**Glebe Island Aggregate Handling and Concrete Batching Facility (SSD 8544)
James Craig Road, Rozelle - Notice of Exhibition**

Thank you for your letter dated 10 April 2018, requesting Transport for NSW (TfNSW) review and comment on the above.

Figure 13 Network Diagram

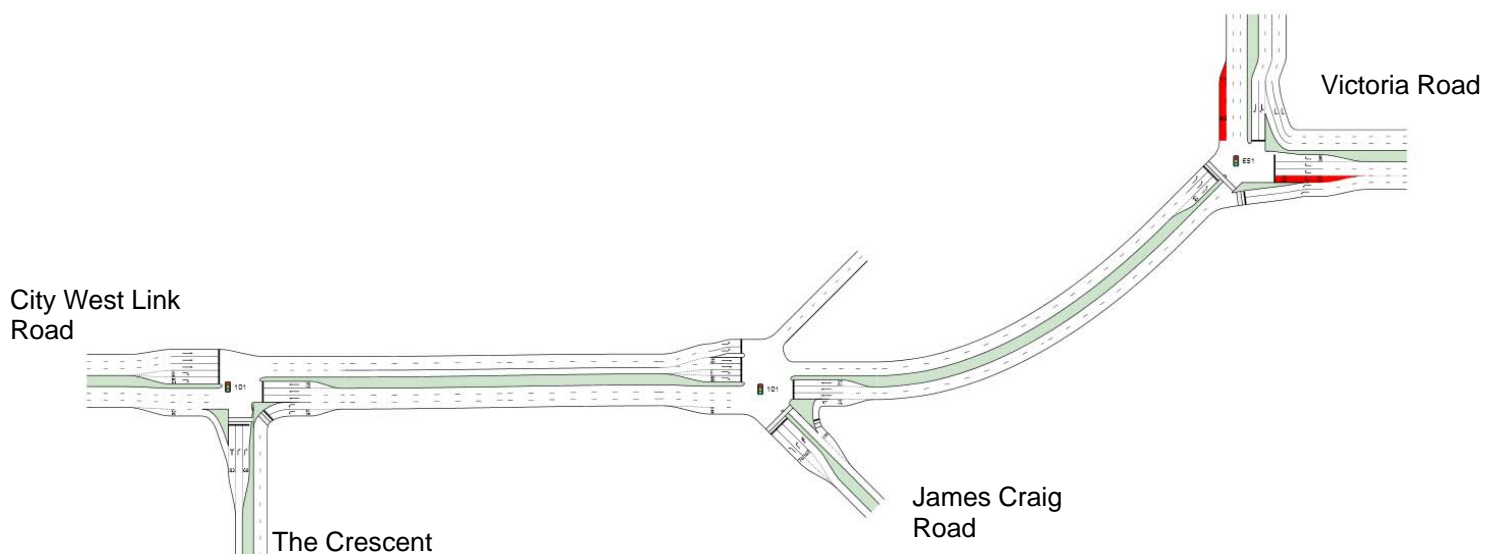
The proposed development is situated adjacent to land that is proposed to undergo significant change in the coming years due to the Bays Precinct development, as well as the construction of several major transport projects, including WestConnex and the Western Harbour Tunnel.

- The intersection assessment, including the future traffic flows on the road network surrounding the site, be updated to include the vehicles associated with other developments in the vicinity of the site, in consultation with the Sydney Coordination Office within TfNSW; and
- Mitigation measures be proposed to reduce the impact of the proposed development on the surrounding road network.
